File No: NTH11/00154; CR2013/001330
Your Ref: SSD_4975

**HW29 Kamilaroi Highway. Watermark Coal Project
Exhibition of Environmental Impact Statement (SSD_4975).**

RMS has undertaken a review of the exhibited Environmental Impact Statement (EIS) and considers that a number of important issues will need to be addressed prior to your Department's determination of the project application.

Figure 32
Watermark Gully Post Mine Flood Level Impacts (2 Year ARI)

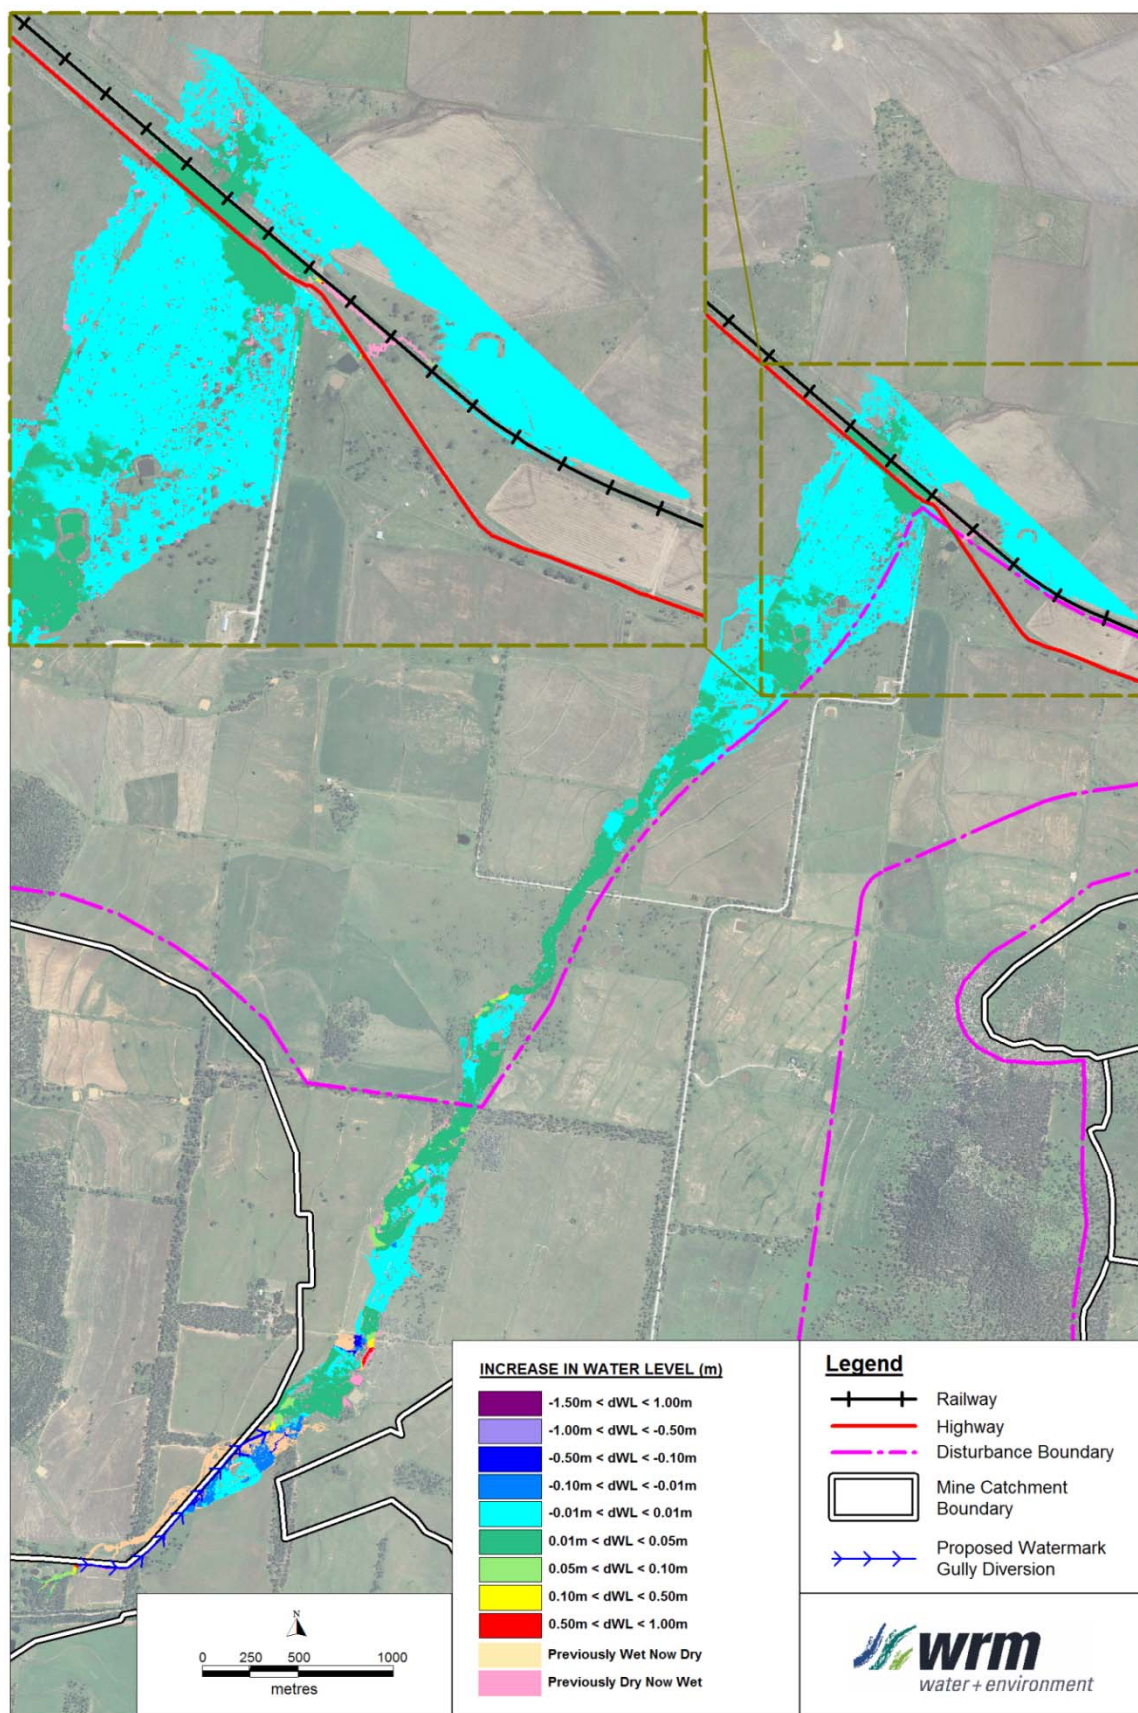
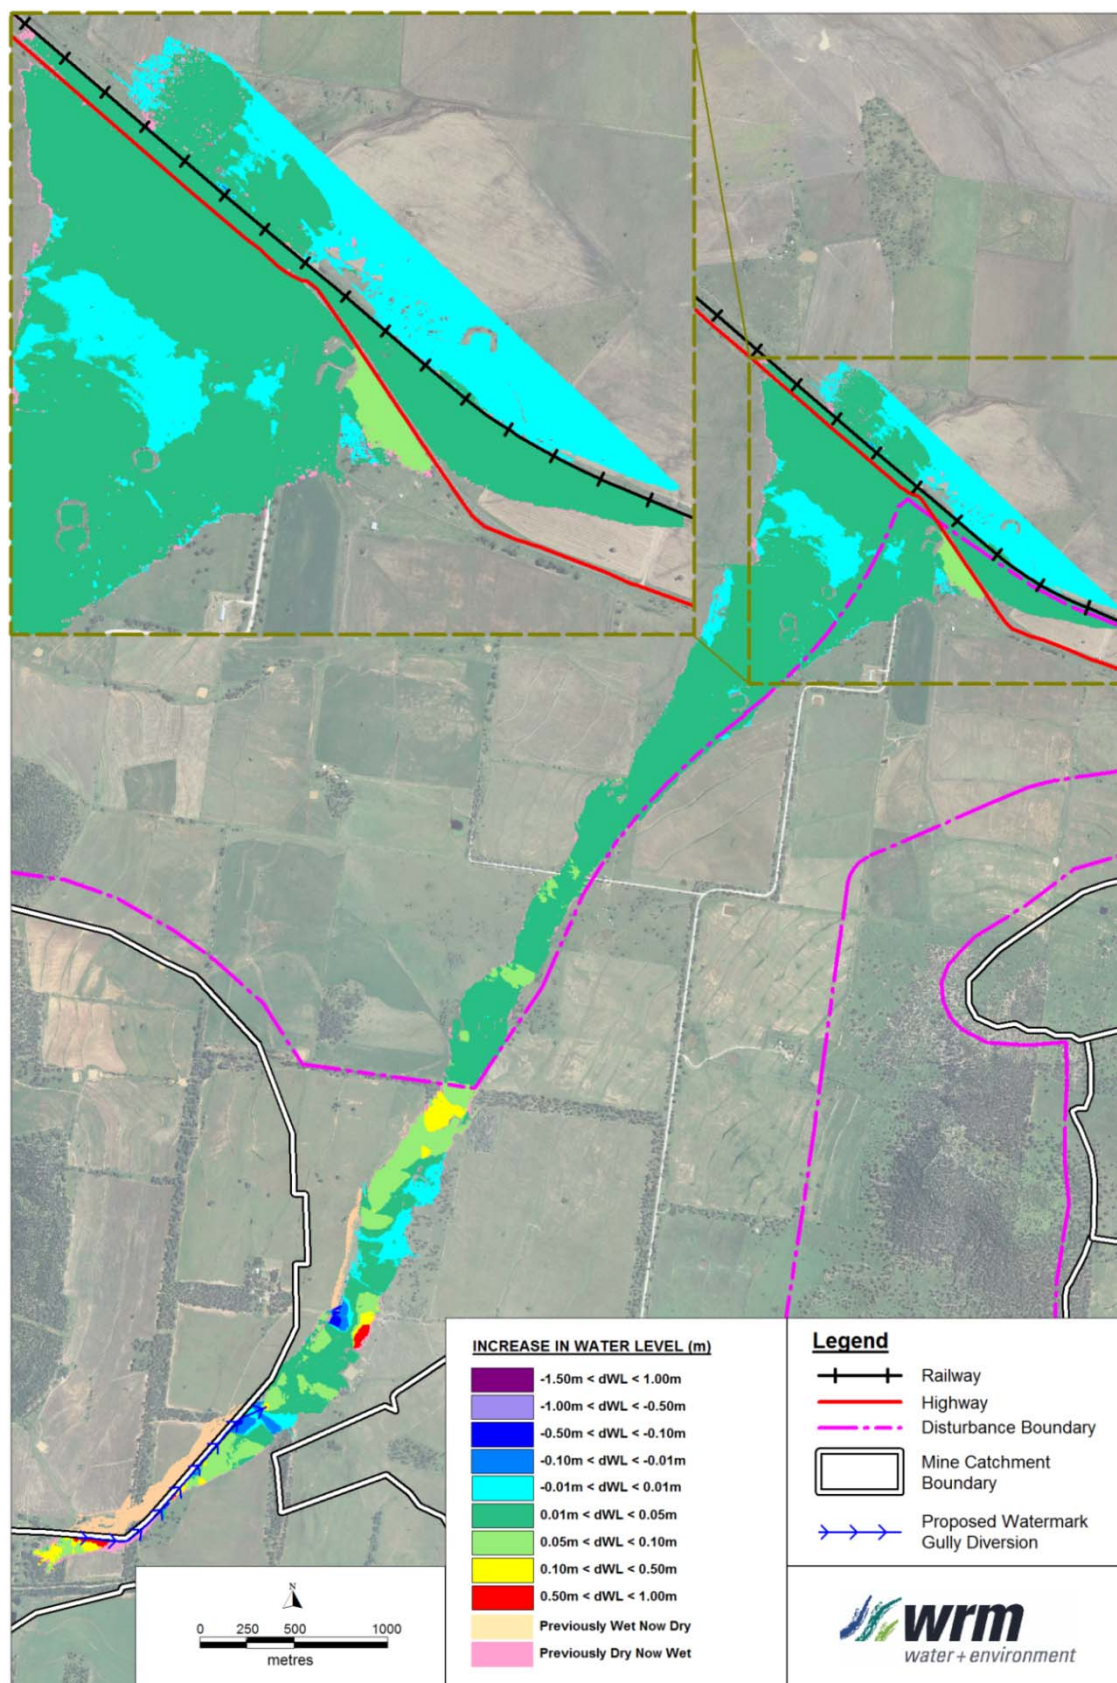
- 2.1 The EIS has identified potential changes to surface water flows in the Watermark Gully catchment with subsequent impacts upon flood related flows affecting the Kamilaroi Highway. RMS notes that the Traffic & Transport Impact Assessment has not addressed the impact of these increased flows on the safety and efficiency of the Highway. RMS requests that the EIS be amended to include a suitable assessment of the impact upon the highway and any proposed mitigation measures required to address these impacts.
